Our ref: STH09/02319/05
Contact: Chris Millet 4221 2570
Your ref: SSD 6334

STATE SIGNIFICANT DEVELOPMENT 6334 – SUTTON FOREST QUARRY PROJECT

Chris Millet
Manager Land Use
Southern Region

**Figure 4** shows the conceptual layout of the Quarry Interchange.

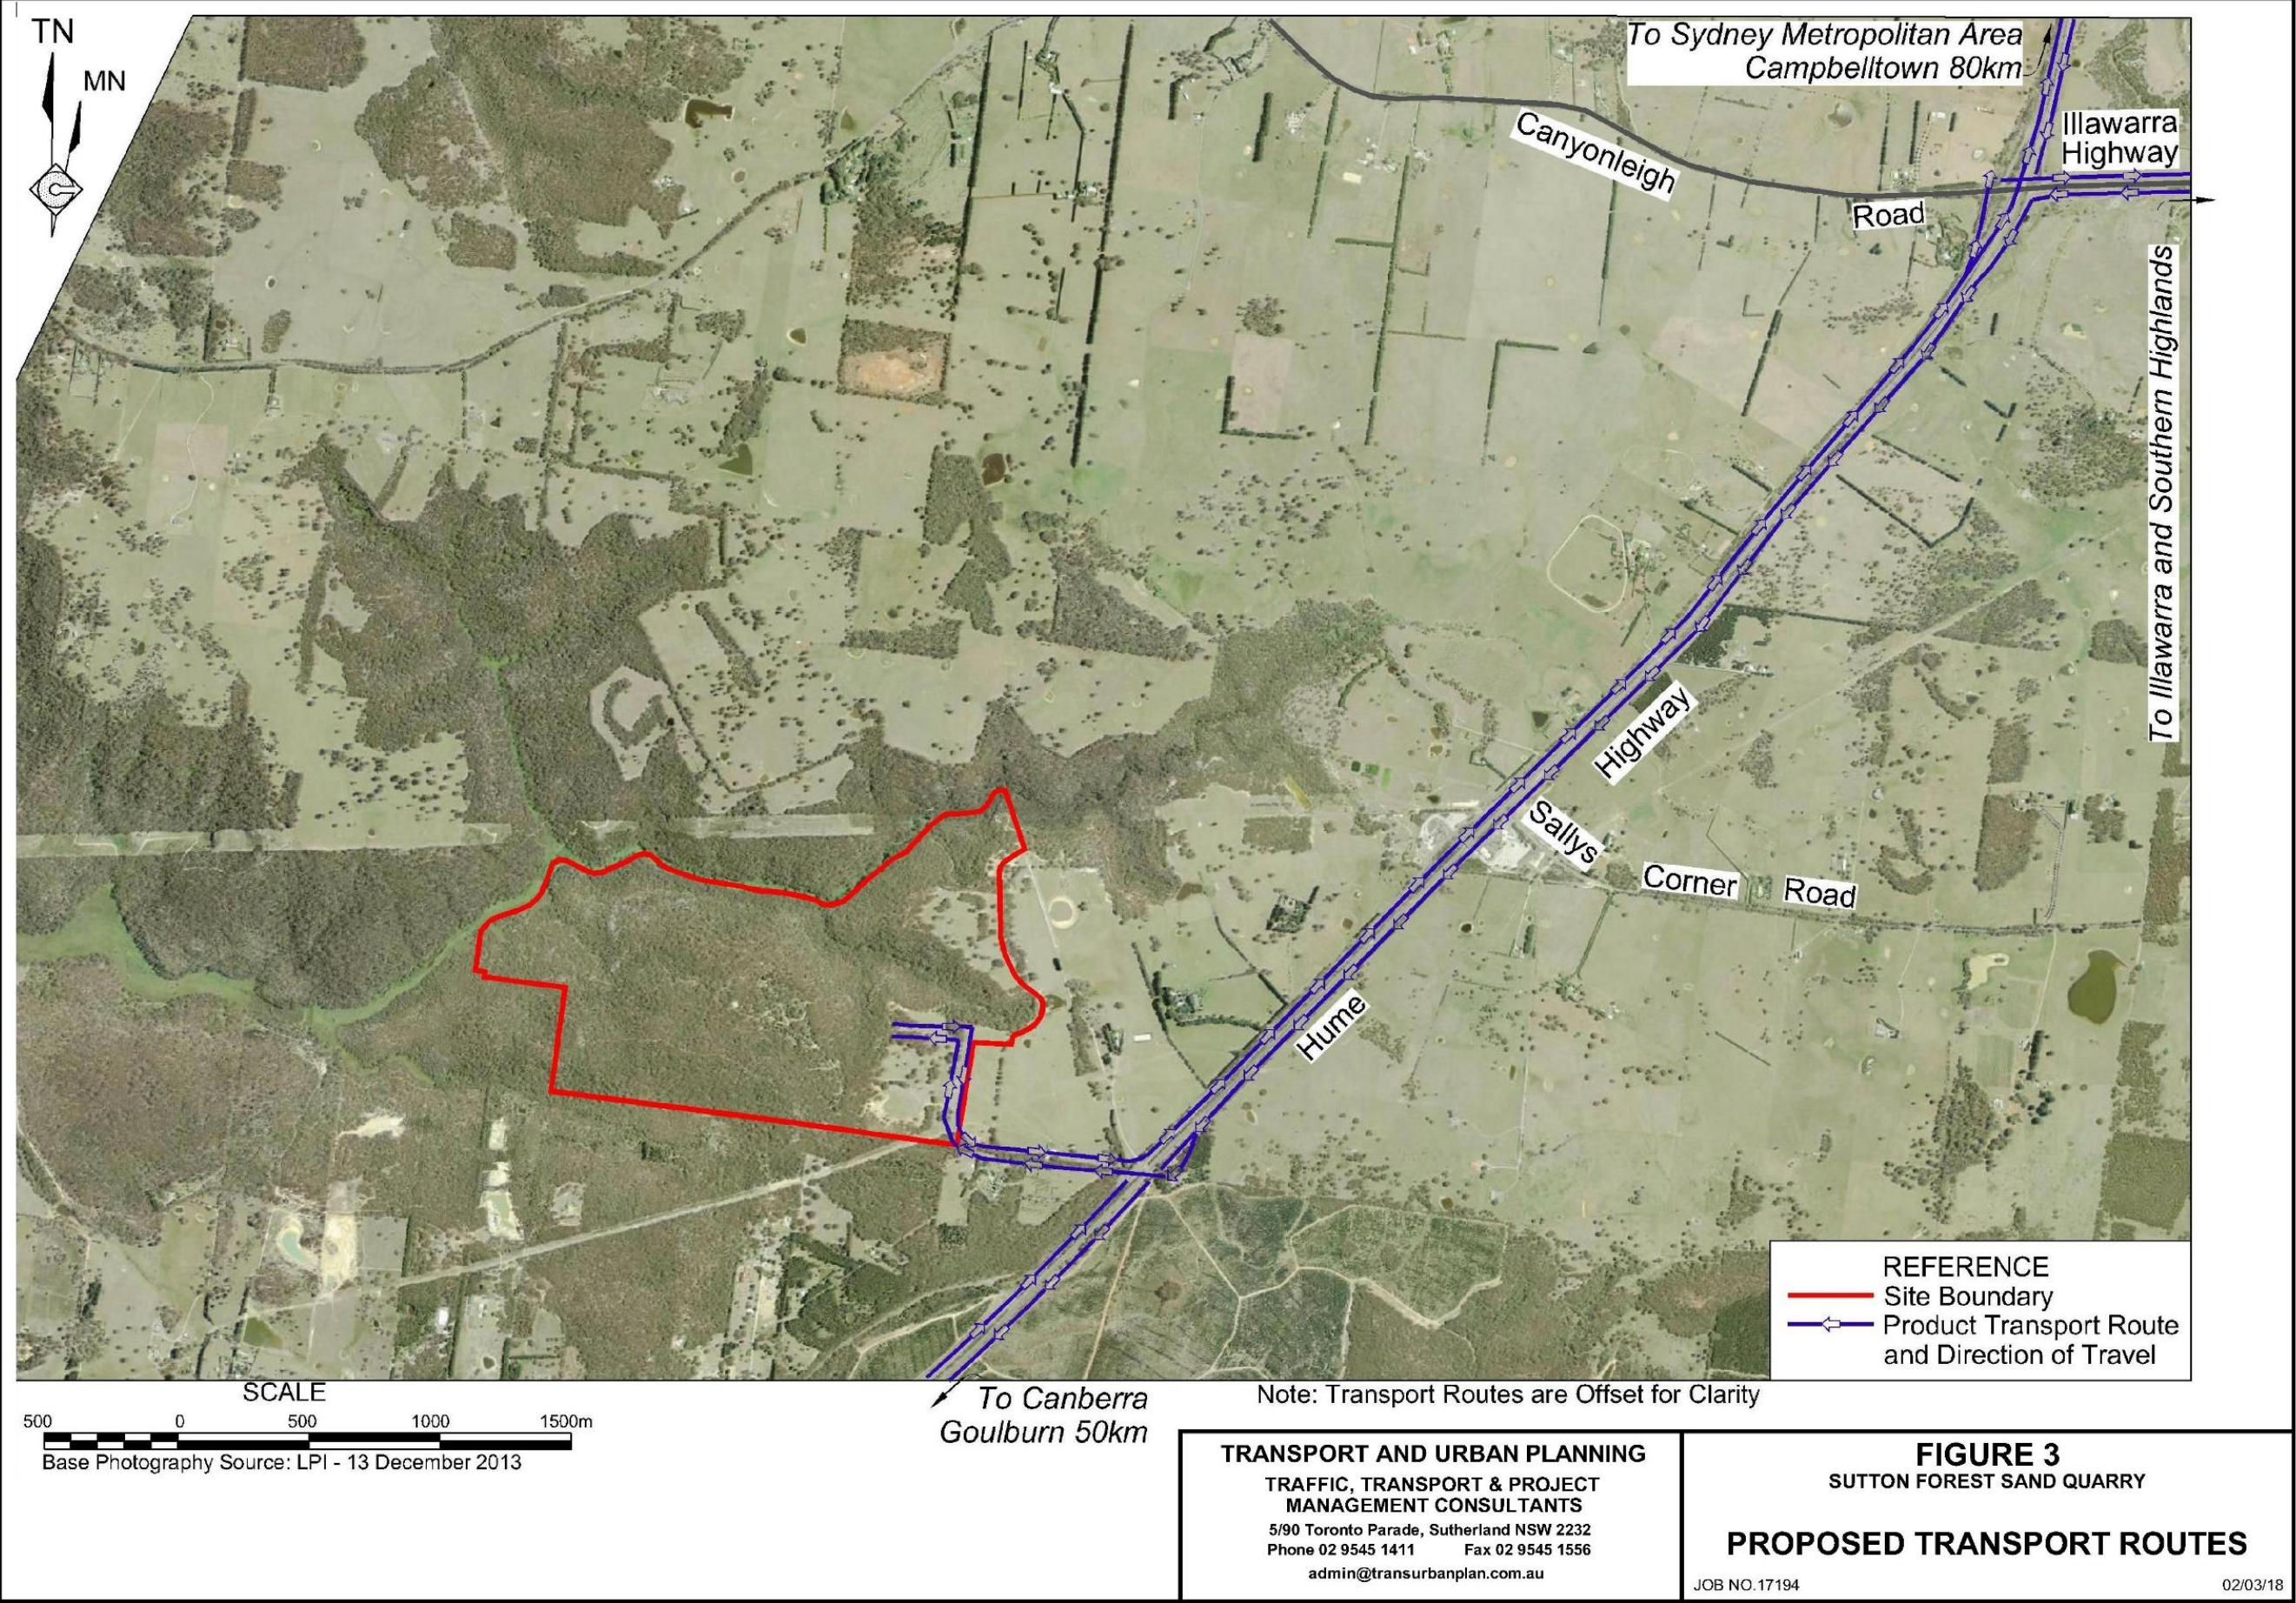
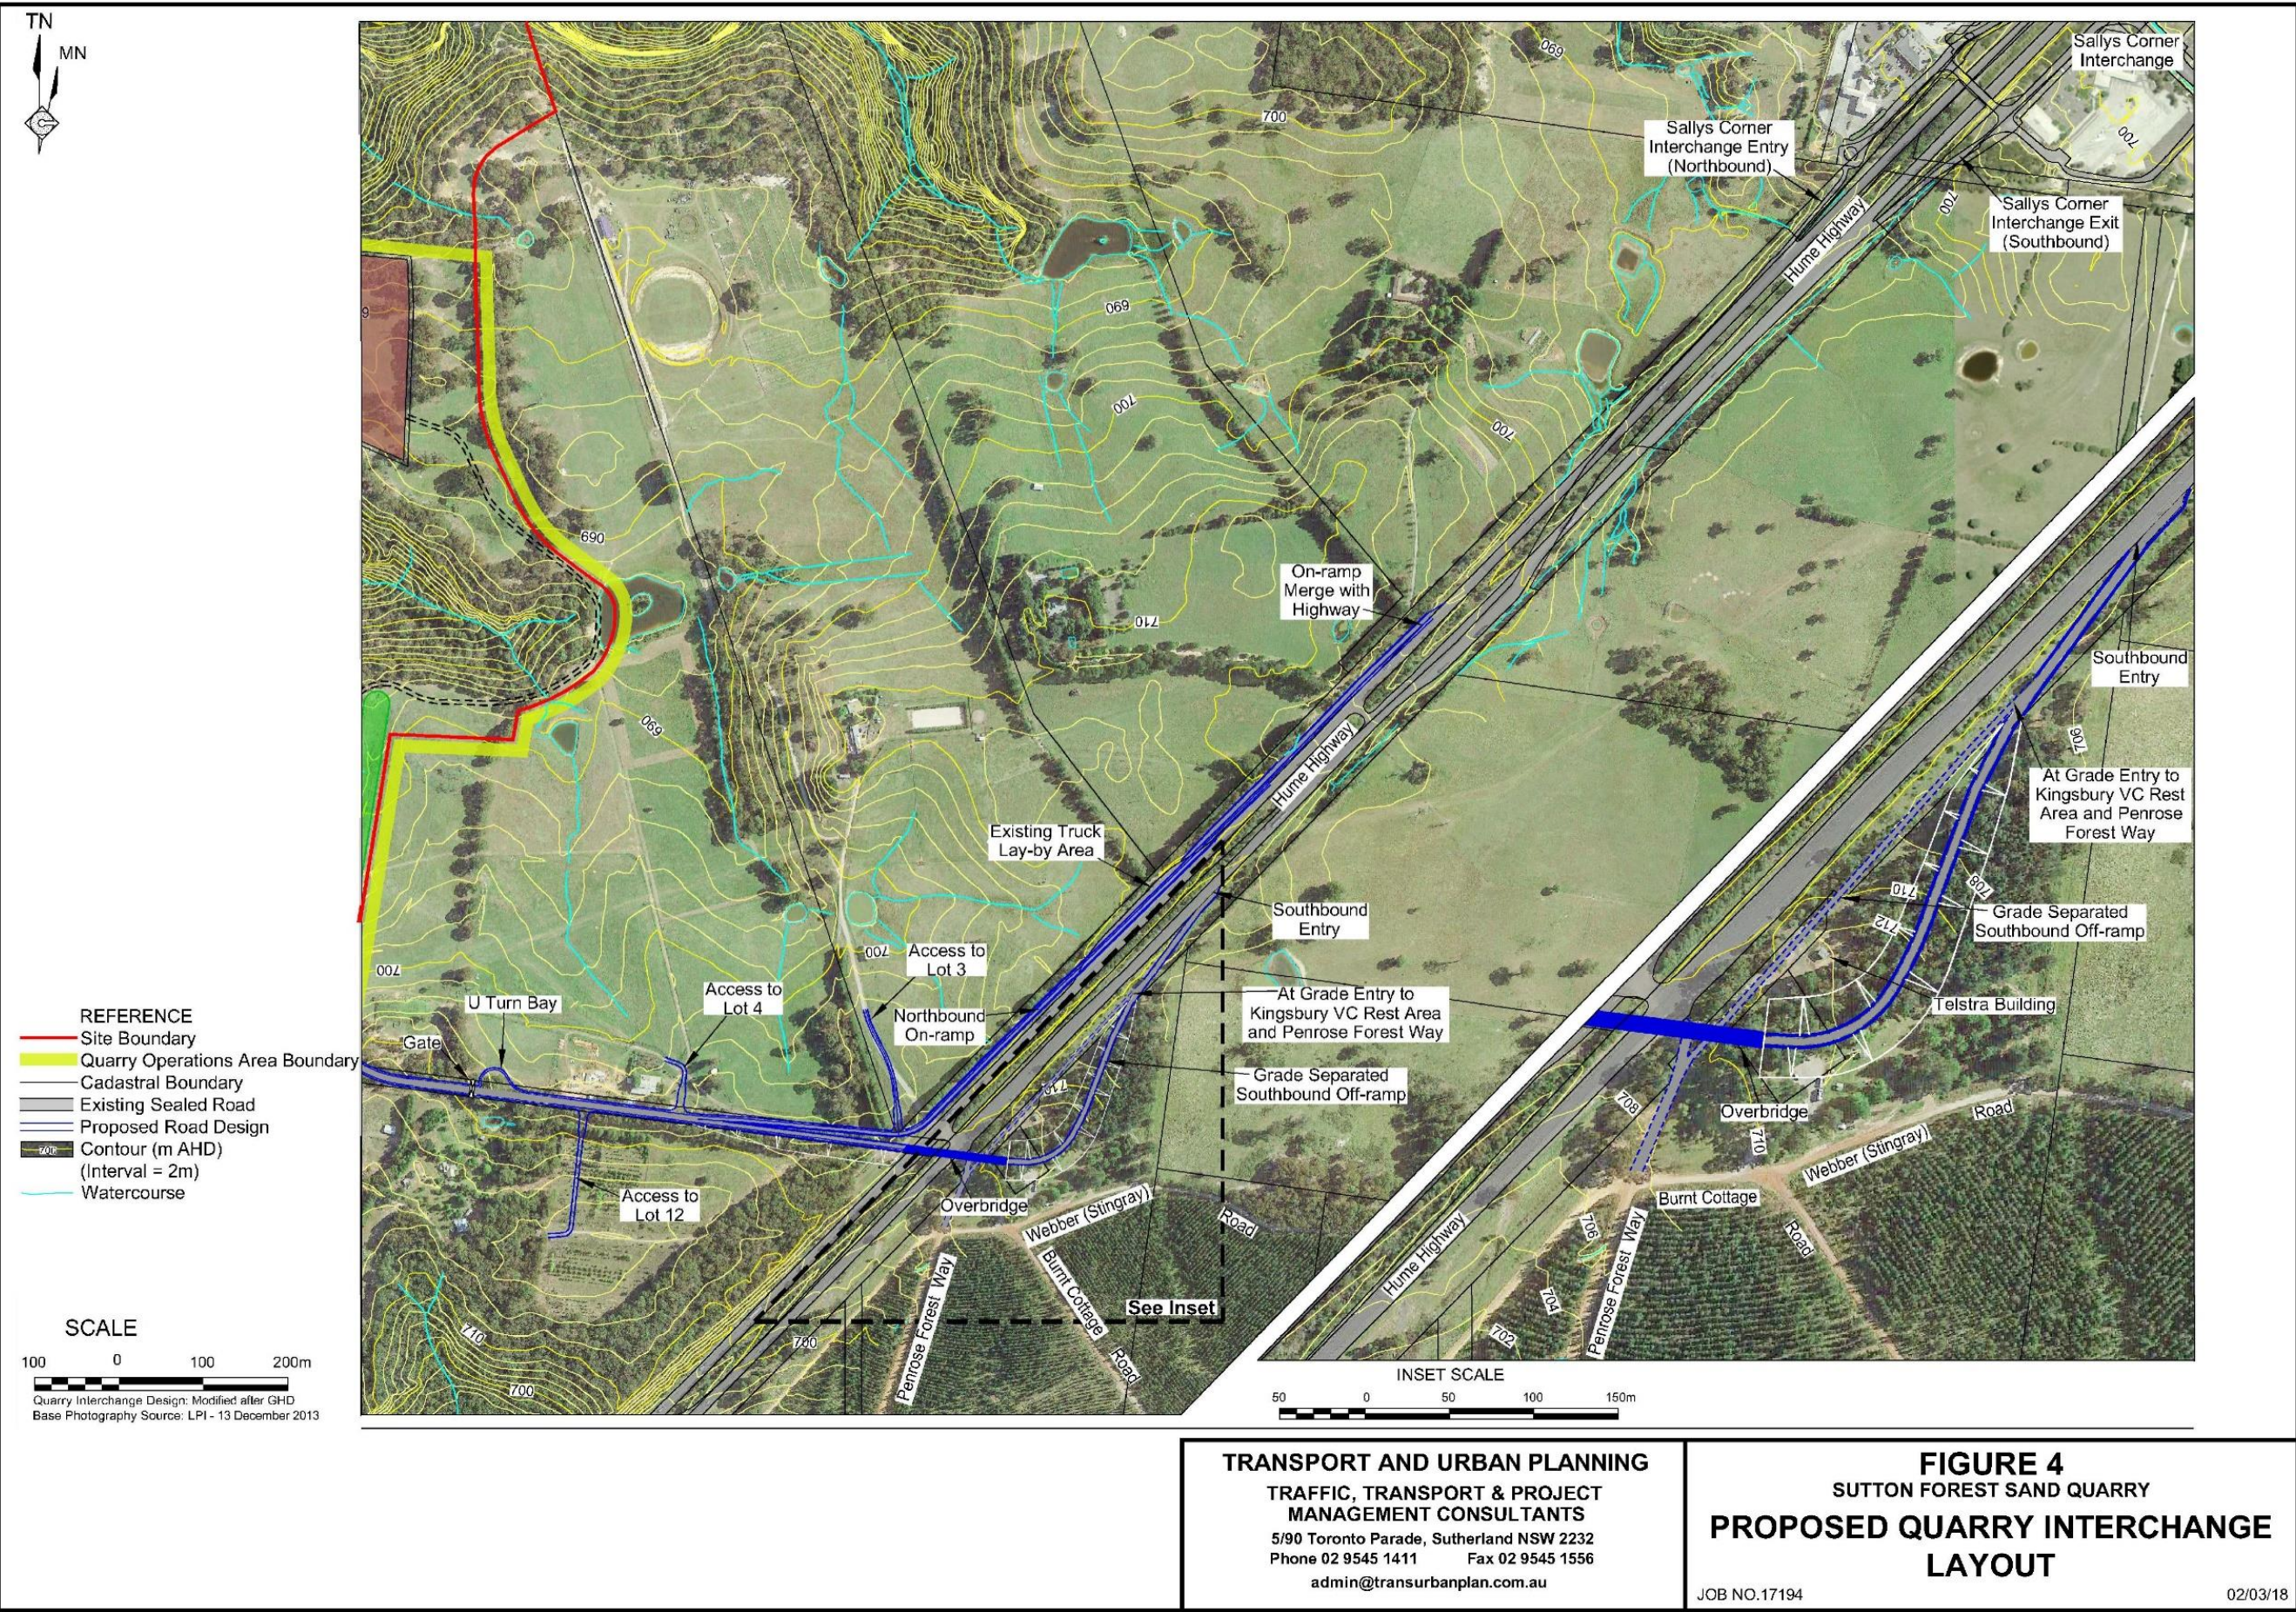
- RMS notes the ramps do not provide connectivity to the Kingsbury VC Rest Area or Penrose Forest Way which are within the immediate vicinity of the offload ramp. The design thereby adds a second left turn offload within the immediate vicinity of the existing offload and a second onload (the northbound ramp) within the immediate vicinity of the existing right turn arrangement (from the Kingsbury VC Rest Area/Penrose Forest Way). This is unacceptable. The grade separated design would need to incorporate access to and from the Kingsbury VC Rest Area/Penrose Forest Way.

- RMS notes the southbound offloads ramps, and its supporting embankments, appear to significantly impact on the Kingsbury Rest Area. Further details of this impact need to be provided as well as any proposed mitigation measures.

- RMS notes the northbound onload ramp appears to pass directly through the existing northbound rest area without mitigating or offsetting this impact. Any proposal which impacts on the existing rest area would need to include the provision of a suitable alternative facility.

- Any proposal for ramps which do not facilitate all movements needs to be supported with an accessibility plan to detail how all movements in the precinct with access the Hume Highway (in all directions), including additional travel times. RMS notes the ramps do facilitate northbound onload from the properties west of the Hume and the southbound offload to these properties. RMS understands the remaining movements between the properties and the Hume Highway (northbound offload and southbound onload) would be facilitated by the Sally's Corner Interchange. RMS is concerned the existing median break between the proposed ramps and Sally's Corner Interchange would be used to facilitate turning movements. RMS does not believe this existing median break is suitable to facilitate such movements.

- The design of the ramps must comply with Austroads Guide to Road Design Part 4C and Austroads Guide to Traffic Management Part 6. There is insufficient detail for these ramps to make a proper assessment. In addition, RMS is concerned the proposed ramps are too close to the Sally Corner Interchange ramps and may create an unacceptable weave issue. A more detailed strategic design would be required to demonstrate the ramps could be constructed in accordance with Austroads standards together with an appropriate analysis to demonstrate these ramps would not create unacceptable weave movements. The weave analysis would need to consider a future 20 year scenario.
